Your ref: 3/2022/0966 and 0967

Date: 2nd December 2022

Applications 3/2022/0966 and 0967:

Crow Trees Farm, Crow Trees Brow, Chatburn BB7 4AA

CLIENT	Pringle Homes				
PROJECT	Proposed Residential Development at Crow Trees Farm, Crow Trees Brow, Chatburn, Clitheroe, Lancashire, BB7 4AA				
DRAWING	Existing Barn - Floor Plans & Elevations				
DRAWN	JAL	DATE	21/09/22	NUMBER	21/139/E03
SCALE	1:100	SHEET	A2	REVISION	-

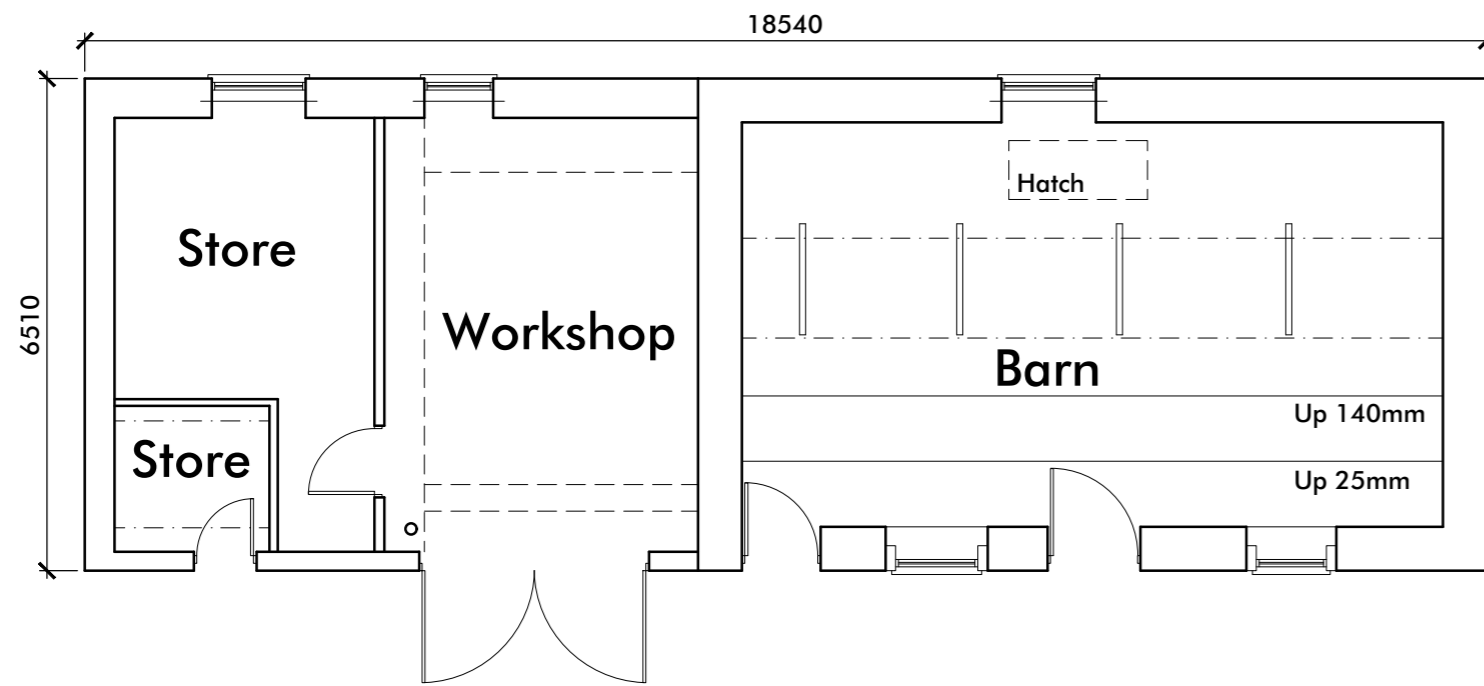
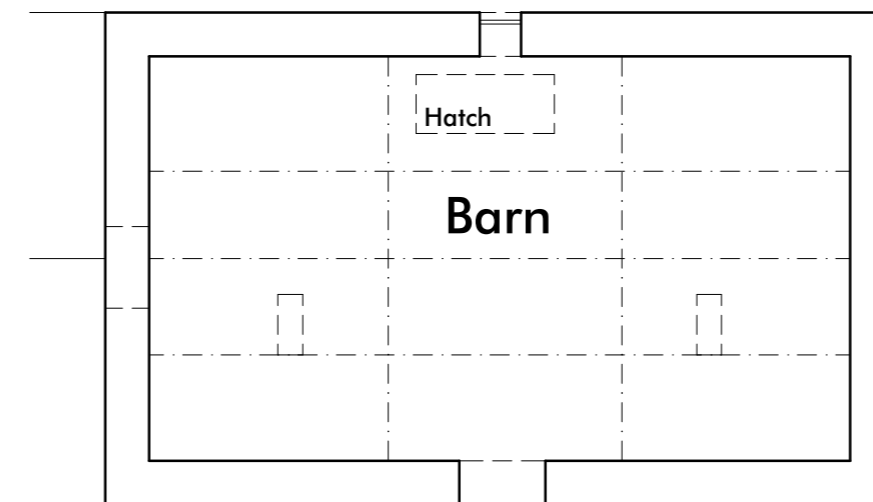
This is very briefly mentioned in the HS (3.51-53.) and a small number of photographs of its exterior are provided, but the interior is not illustrated, and it is not discussed in any detail. It appears on the OS 1847 mapping, but the images in the HS suggest that stylistically it should be associated with the later 'Cheese Room' extension to the farmhouse. This would suggest that it is of 18th or early 19th century origin. The building is of some architectural merit, presumably reflecting the status of the adjacent farmhouse.

Several images of the interior and exterior of the building are provided in section 10 of the Structural Survey, where it is referred to as the 'Main Barn'. These would suggest that it is indeed of later 18th or early 19th century origin, with the single-storey extension to the southern gable (SS section 11 'Workshop') being a later addition. It seems possible that the single storey element was once open-fronted (e.g. 'inset' panel SS figure 11.1.3; possible iron post SS figure 11.2.1) and has been closed in in more modern times. Significant structural concerns are raised regarding these buildings, and it seems probable that significant repair or reconstruction will be necessary (SS 14.5 and 14.6 pp.39). Whilst there are stalls recorded on the ground floor of the barn, the images in the Structural Survey show these to be of cement and metal, and thus likely to be of mid-19th century date or later and of only very minor historic interest. Their loss as part of the proposed conversion is thus of little import. The timbers to the first floor are, however, likely to be original to the building and should be retained as far as possible, even though works are recommended to stabilise the walls (SS 14.5, p.39). The originality of the main roof timbers is less certain, with the Survey suggesting that they may have been replaced (SS 10.2, p.31, figure 10.2.3).

No new openings are proposed on the main front of the building, facing towards the Listed farmhouse, but a considerable extension in a modern style is proposed to its rear, with a new stair in a glass link section between old and new parts. The extension appears to be mainly hidden from the view of the historic house, and the face presented towards Crow Trees Barn to its north is essentially blank and could be taken as 'agricultural' in character. It is a concern that the Structural Survey recommends that much of this building is demolished and rebuilt, in some places down to ground level and with foundation works also being required. Combined with the new extension, this could be taken to be recommending what is in effect a new build, albeit with some retained and re-used architectural components – a substantial negative impact on its heritage

value. Whatever the decision of the council regarding this element of the development, we would recommend that a formal building survey be undertaken prior to any works commencing. Given its relatively simple layout and appearance, that it is not individually Listed and that the Heritage Statement claims that it cannot be considered curtilage listed, this record can be to the lower Historic England level 2.
